Ribble Valley Borough Council
Council Offices
Church Walk,
Clitheroe
Lancashire
BB7 2RA

Phone: 0300 123 6780
Email: developeras@lancashire.gov.uk
Your ref: 3/2026/0476
Our ref: 3/2026/0476/HDC/KW
Date: 10 September 2026

Location: Land north of Woodpecker House Sawley Old Brow Sawley BB7 4LF
Proposal: Proposed construction of one single-storey short-term holiday let.
Grid Ref: 377884 446771

The Local Highway Authority (LHA) are in receipt of an application for the proposed construction of one single-storey short-term holiday let at Land north of Woodpecker House, Sawley Old Brow, Sawley.

Drawing Title
Proposed Site Plan

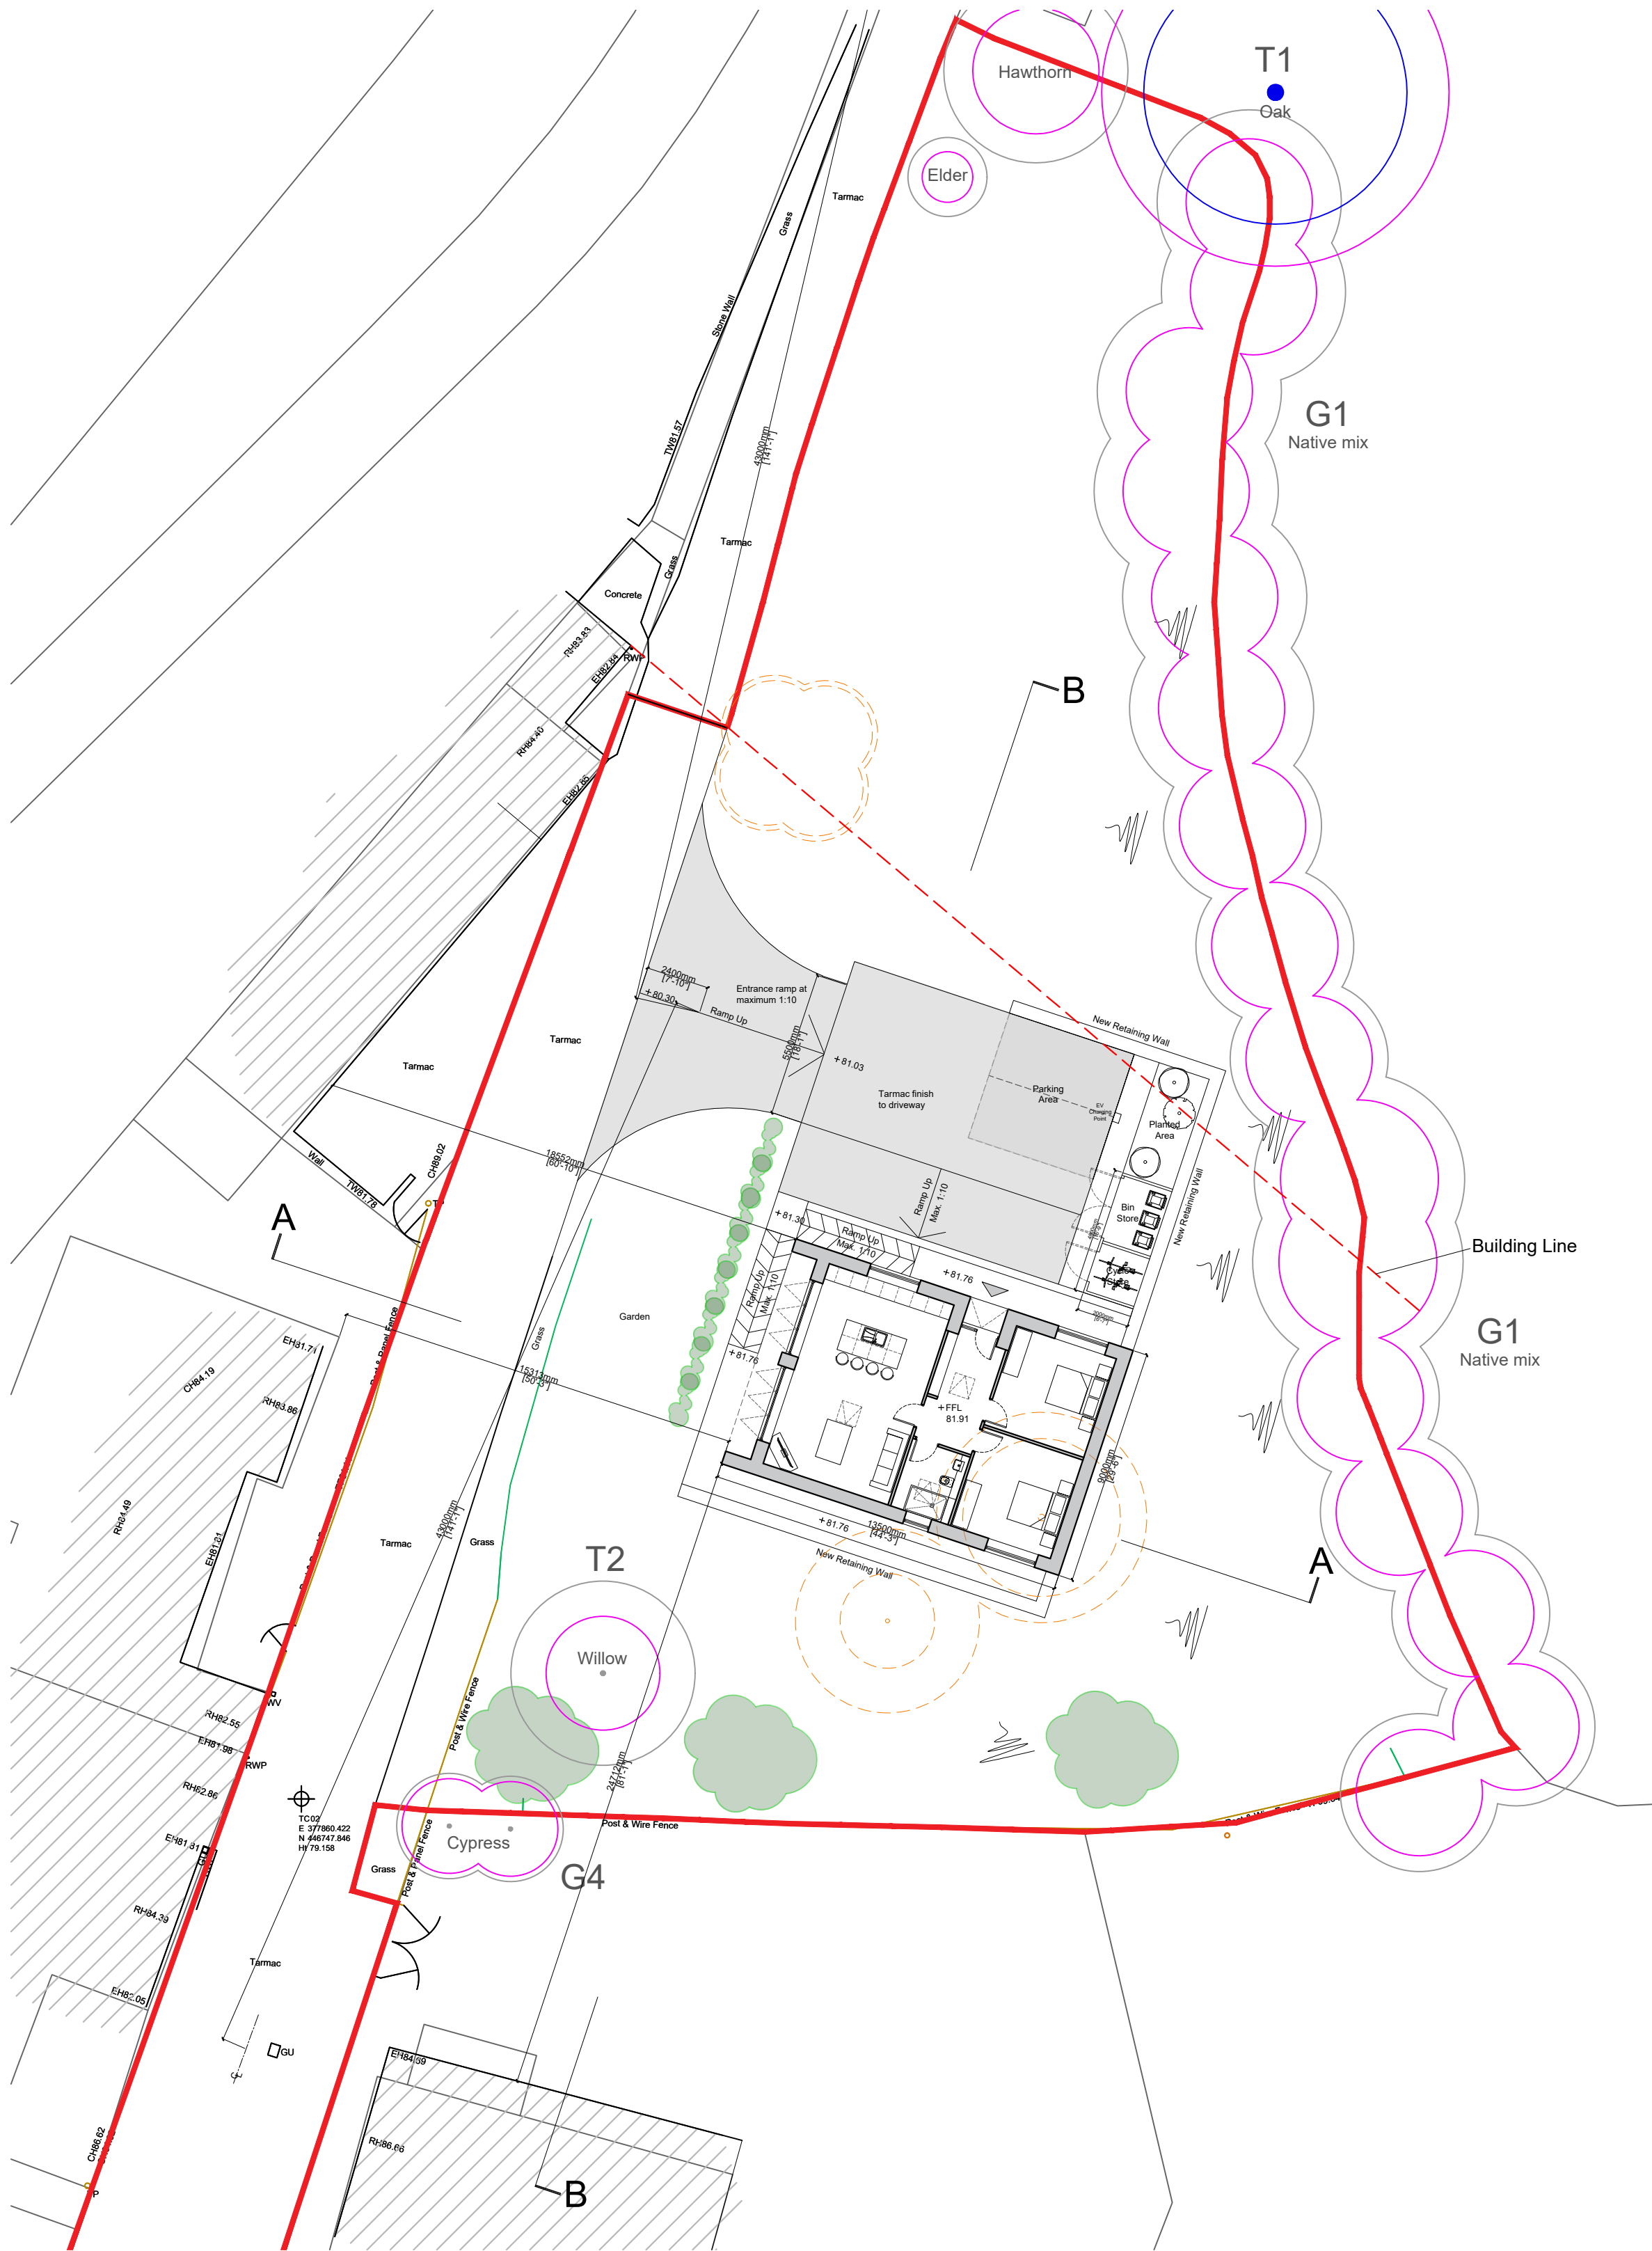
There are sufficient visibility splays at the Sawley Old Road junction and road width to accommodate the development traffic. The applicant has provided a visibility splays drawing at the site access which shows visibility can be achieved at 2.4m by 43m in both directions along the private unnamed road. All boundaries and vegetation within the splay should be kept and maintained below 1m high.

The proposed site access is 5.5m wide with a maximum gradient of 1:10 for vehicles. It should be advised that a gradient of 1:20 should be provided for wheelchair users where required. The area needs to be paved and drained to ensure that the surface water is

collected within the site and to avoid loose debris being deposited onto the road. If any gates are added to the site access, they should be set back by at least 5m from the edge of the carriageway.

The provision of 2 car parking spaces and a cycle store for bicycles is proposed on the plans which is sufficient in accordance with maximum car parking standards.
